**Subject: Heritage Branch comments on Public Exhibition of Environmental Assessment for the Appin Drainage Project Modification (08\_0255 Mod 2).**

**Exhibition of Environmental Assessment  
Appin Goaf Drainage Project 75W Modification (08\_0256 Mod 2)**

**Re: Exhibition of Environmental Assessment – Appin Goaf Drainage Project 75W  
Modification (08\_0256 Mod 2)**

**NSW OFFICE OF WATER COMMENTS ON ENVIRONMENTAL ASSESSMENT  
APPIN GOAF DRAINAGE PROJECT (08\_0256 – MOD 2)**

Mine Safety Gas Drainage Site Plan

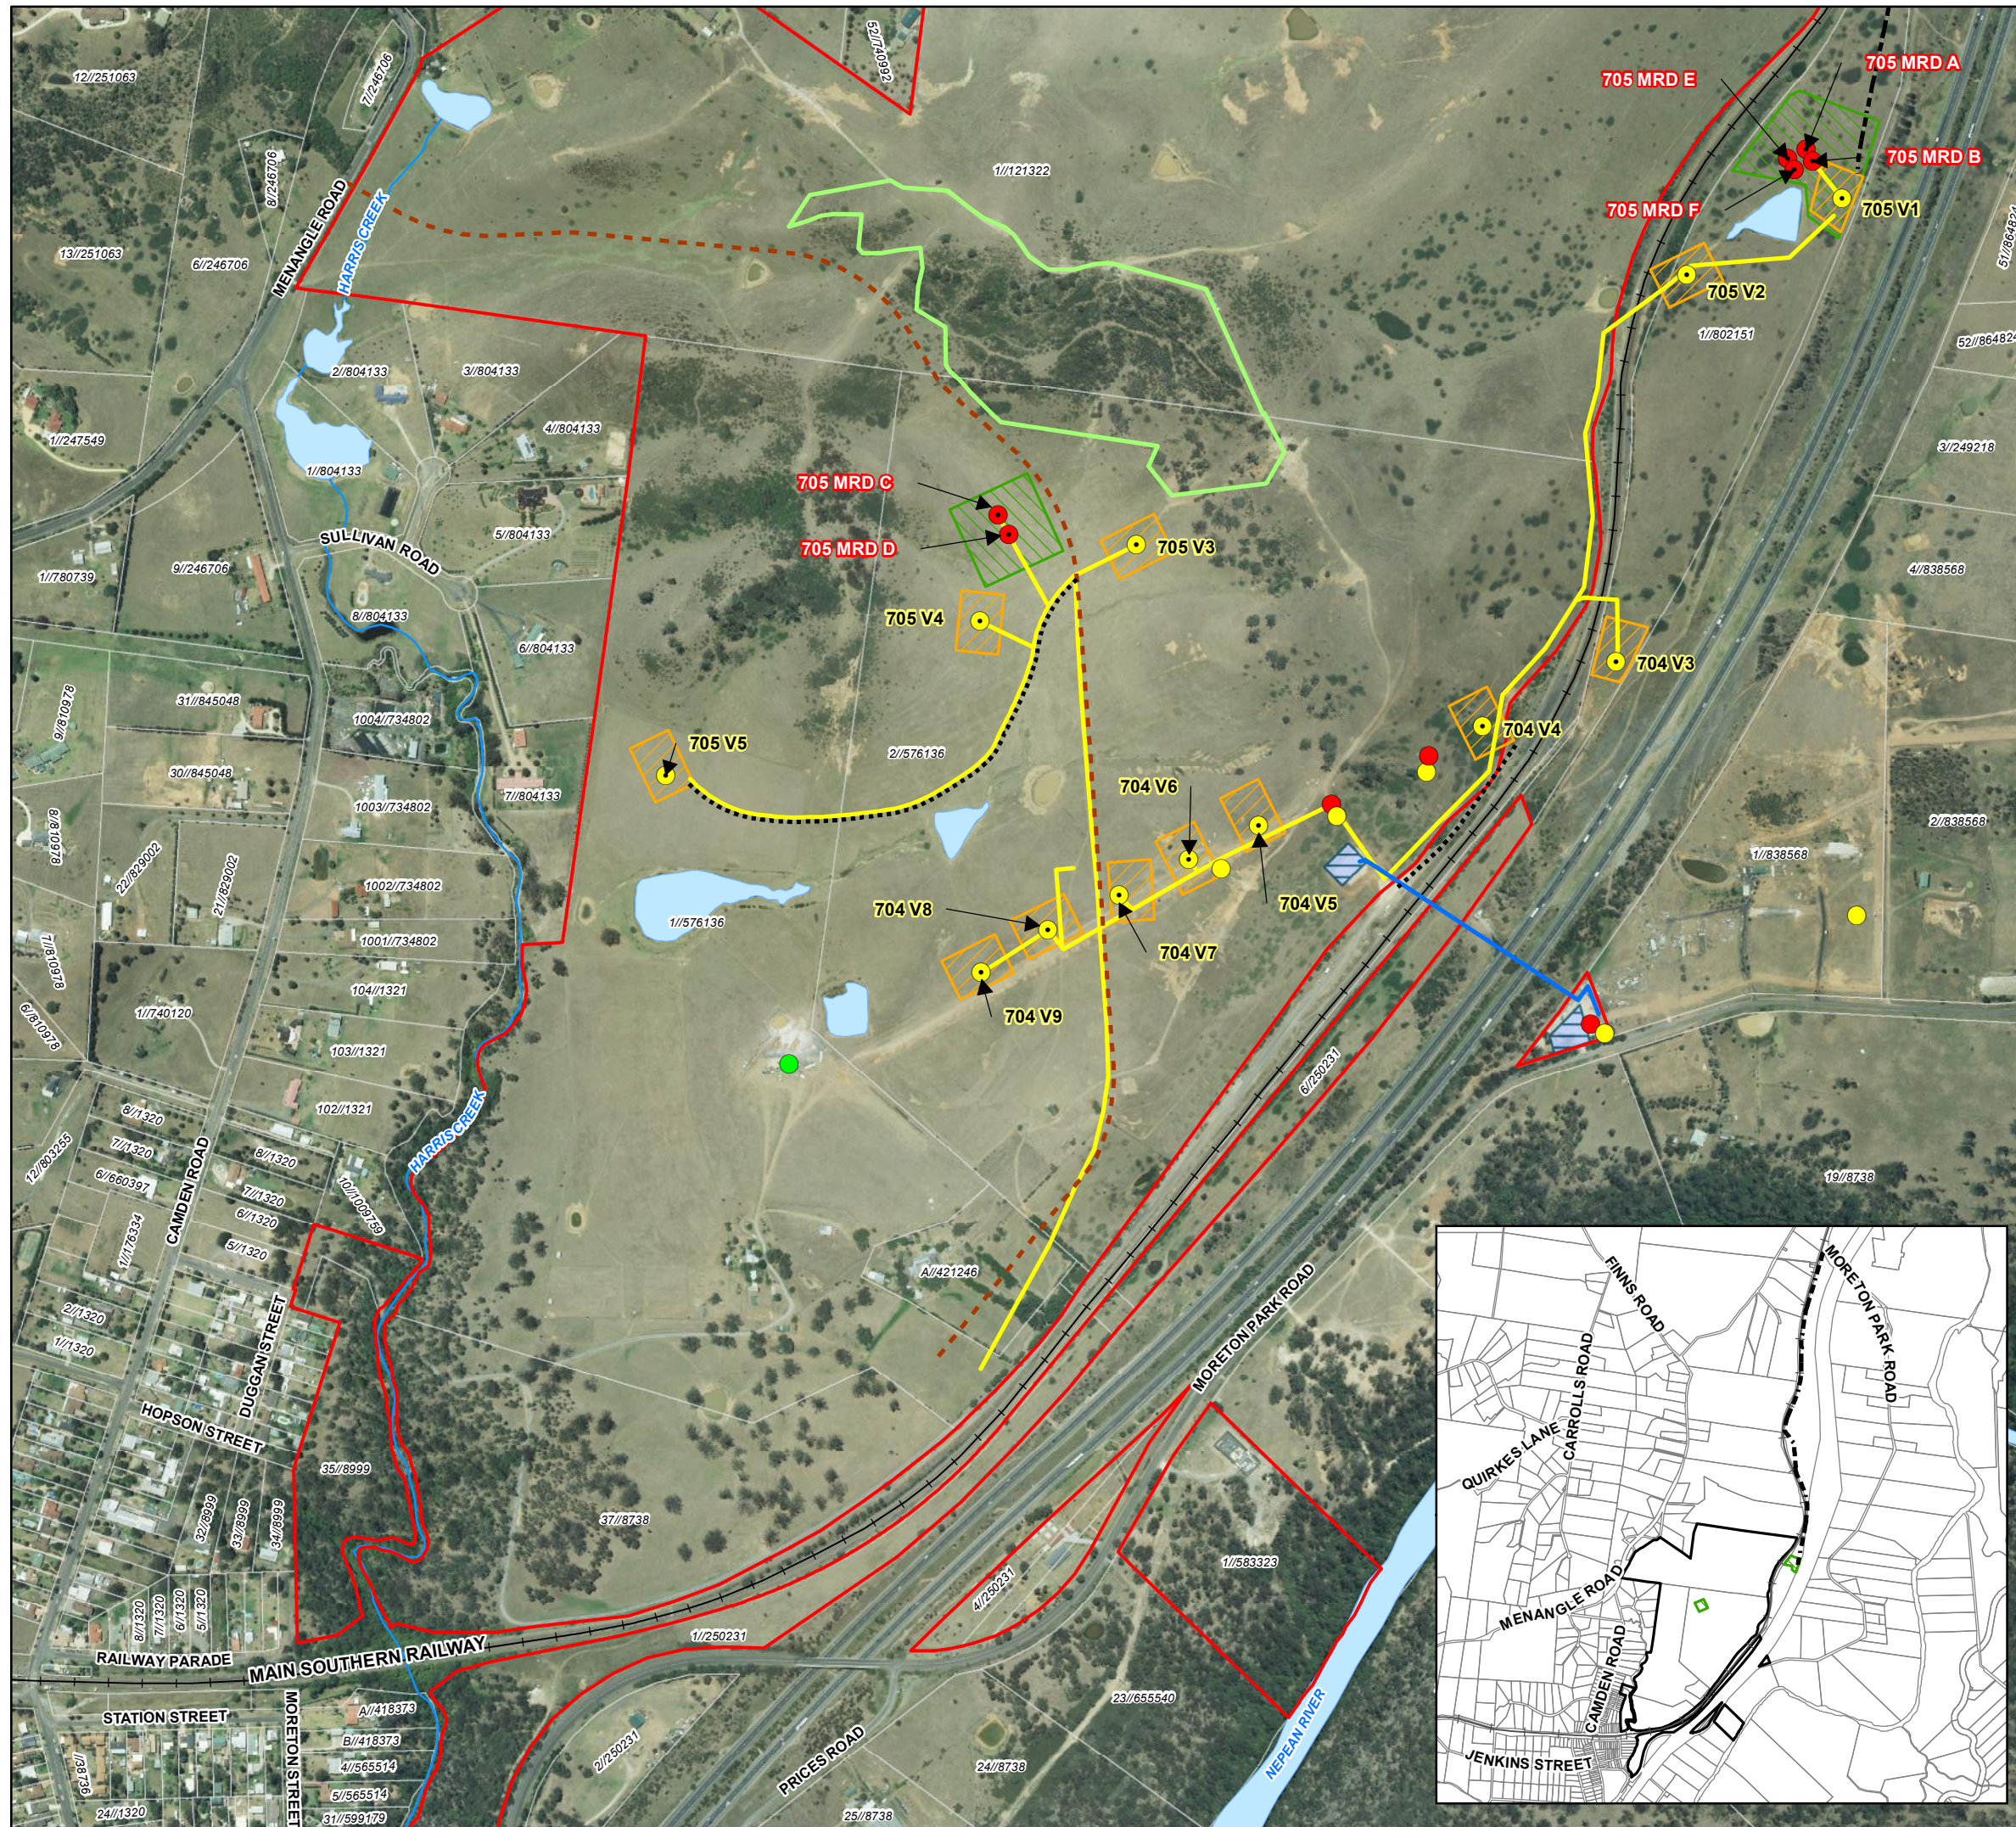
RMS have reviewed the submitted information and note that the modification proposes a new temporary access and an upgrade of an existing access to Menangle Road. It is further noted that there are two options provided for access to Site 1. RMS does not support the first option proposed for access to Site 1 due to sight distance limitations to the south west and require that the "contingency" access location be used.

- The proponent shall remove any vegetation adjacent to the access points which impede sight lines between the access and Menangle Road.
- The "contingency" access location shall be used to provide access to Site 1.

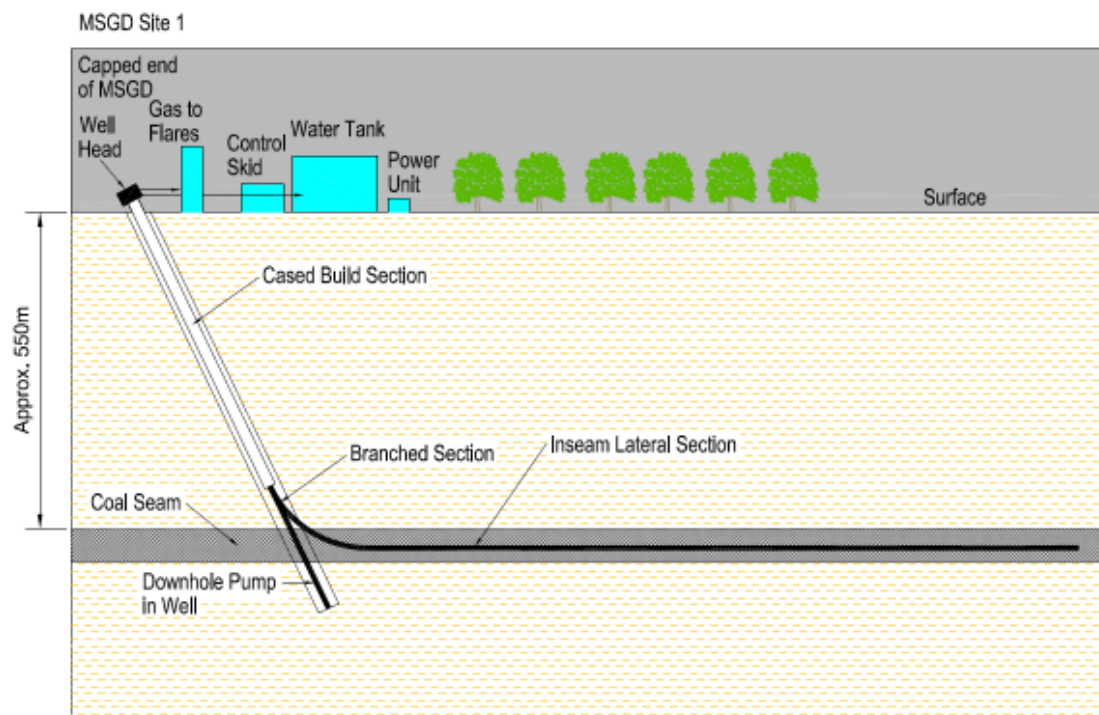
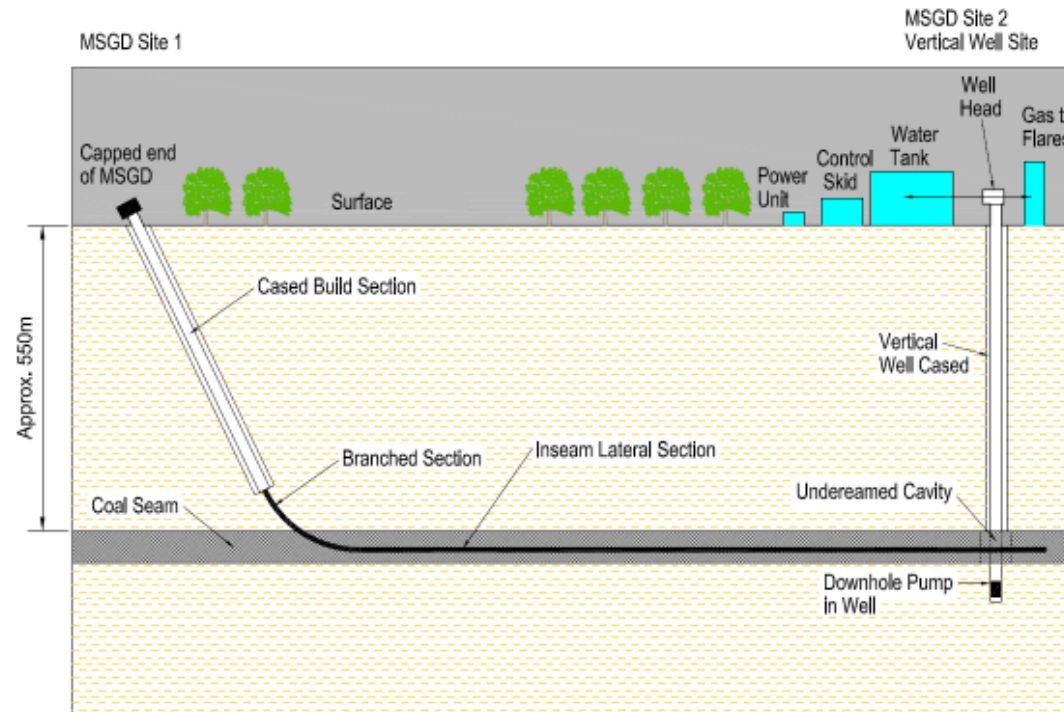
The Section 2.5 of the EA provides a number of schematic representations of the proposed borehole designs. These boreholes should be constructed to a standard consistent with the *Minimum Construction Requirements for Water Bores (2<sup>nd</sup> Edition)*, including requirements for casing, cementing and preventing cross aquifer contamination. The statement of commitments suggests that the directional drilling (MRD and MSGD) wells will be constructed with casing extending to the top of the radial section (approx 450 - 500 metres depth), which is "considerably below any regionally significant aquifers", however the Bulgo sandstone appears to extend to this depth, and this unit is described on page 5 of Appendix E (Geoterra Groundwater Impact Assessment), as one of the most significant aquifers within the overburden. Casing should extend through the radial section if there is any likelihood of encountering groundwater in this zone. The EA suggests that vertical bores will only be cased to the top of the Bulgo Sandstone Unit. No reason is given why the Bulgo unit should not be cased. The appropriate drilling design should be determined in consultation with NOW hydrogeologists.

2. Construction of all wells must be undertaken by a driller holding a water driller's licence, valid in New South Wales.
3. Bores should be designed consistent with the *Minimum Construction Requirements for Water Bores (2<sup>nd</sup> Edition)*.
4. Detailed bore design should be submitted to the Office of Water for approval prior to the commencement of drilling.
5. A NSW Office of Water hydrogeologist should be notified 28 days prior to the commencement of drilling.

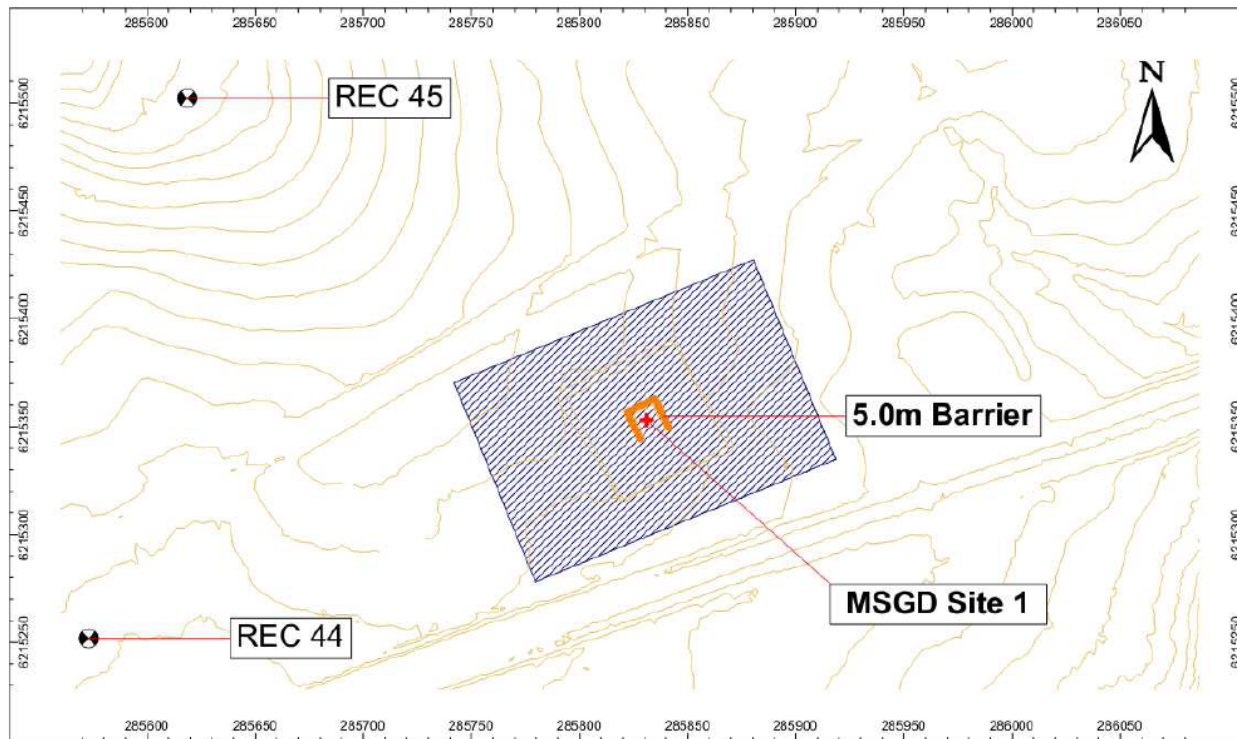
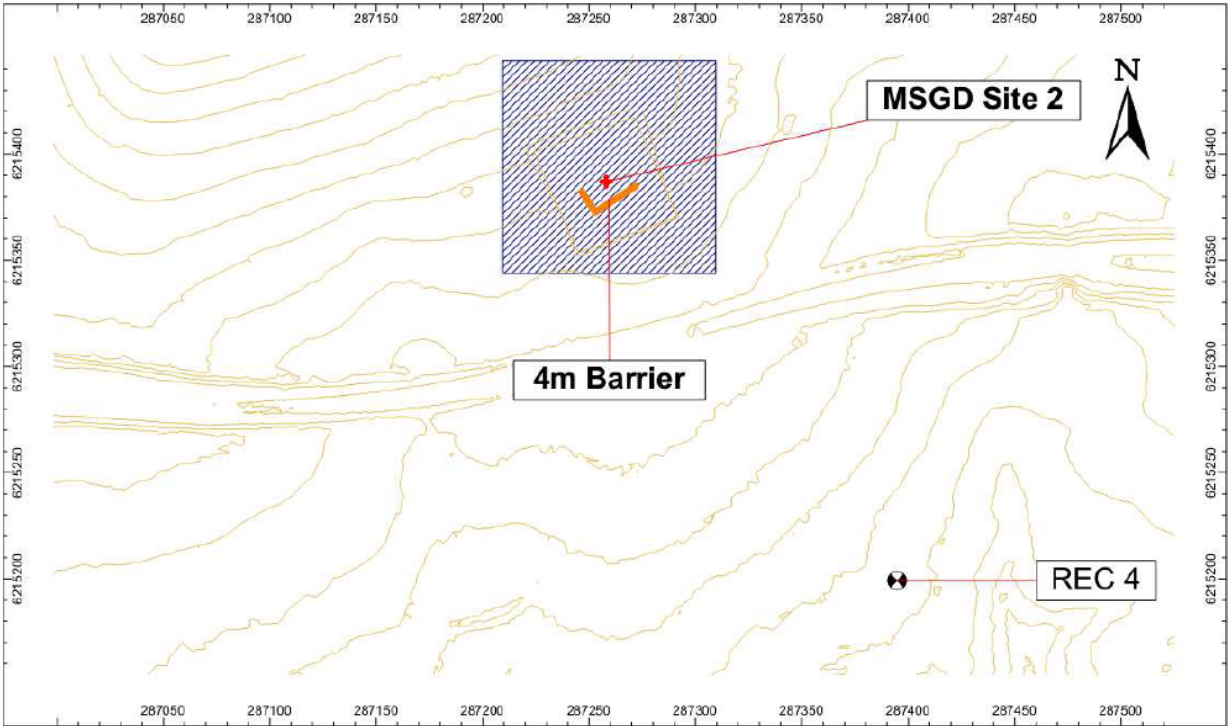
The Environmental Assessment (EA) states that the exact siting of the proposed noise barriers will be determined at the time of the construction works. This is to allow for equipment dimensions, layout and operational requirements to be considered. Part of this determination will include developing the dimensions of the noise barriers to enable the barriers to achieve their required performance.

The Environment Protection Authority (EPA) suggests that this assessment and siting process as well as ongoing management of the barriers be incorporated as part of a Noise Management Plan. This Plan should also specifically consider containing flanking noise from around the barriers. The EPA suggests the proposed notification to potentially affected receivers that are likely to hear the proposed night-time works be included in the Plan.
